**Consultation Response from KC,  
Lead Local Flood Authority**

**2025/92737 rear of, 23 to 43, Moor Lane, Gomersal, Cleckheaton, BD19 4LF**

**Date Responded: 05/11/2025.**

**Discharge of Drainage Conditions**

Private Drainage

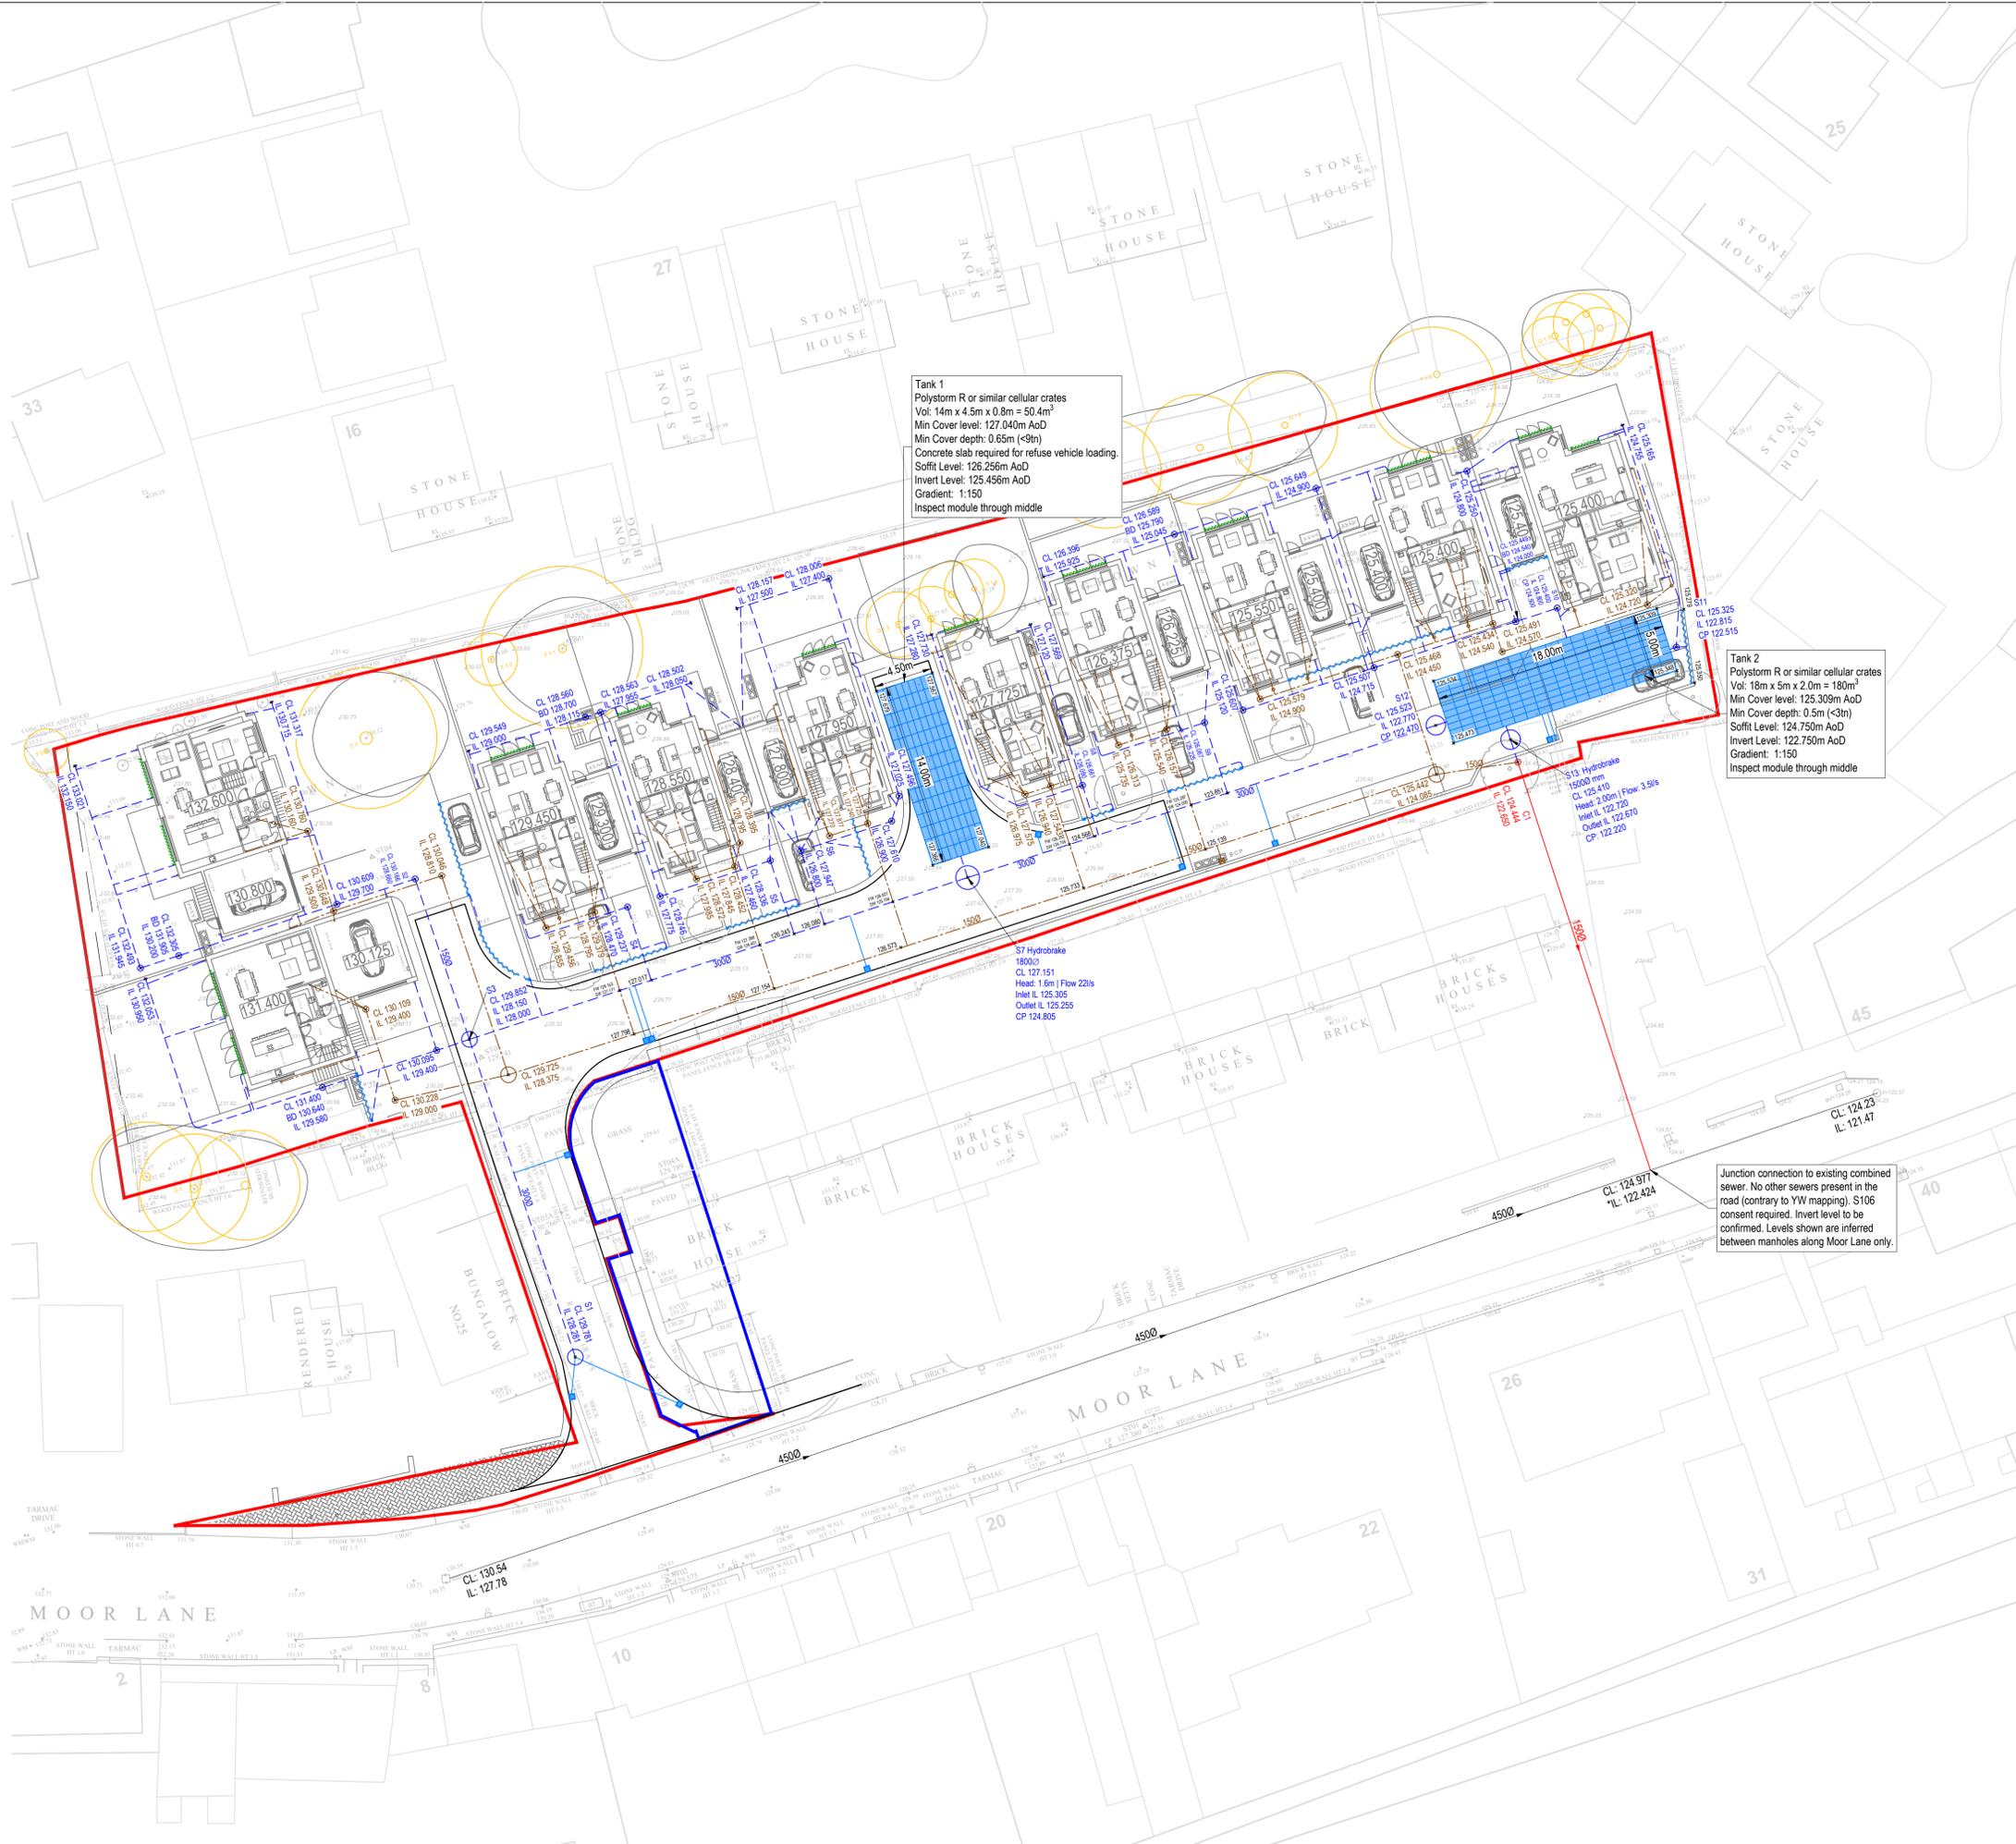
The drainage proposals indicated on drawing PV2511-APP-92-XX-DR-C-2500 are generally accepted by the LLFA including the proposed allowable discharge rate off site for the surface water drainage of 3.5l/s and the proposed connection to the YW Combined Sewer in Moor Lane (subject to YW approval).

Regarding the final attenuation tank, the LLFA would expect that MH S12 should be of the silt trap PCC ring type to reduce the risk of siltation entering the tank.

**Polystorm Attenuation Tank 1**  
**Plan View**  
 (Scale 1:20)

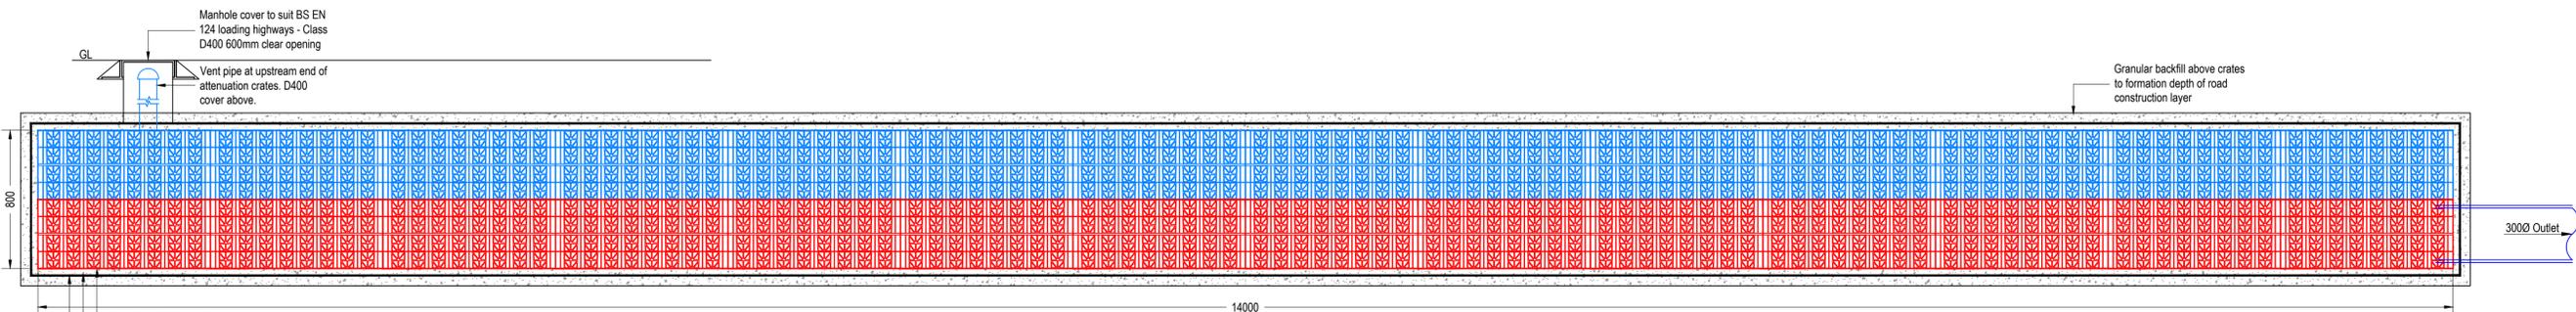
However, before this condition can be fully discharged, the remaining requirements regarding the construction details of the attenuation tanks (as set out in the Planning Decision Notice Condition 16) will need to be addressed. Particular attention should be paid regarding how the tanks will be inspected and maintained.
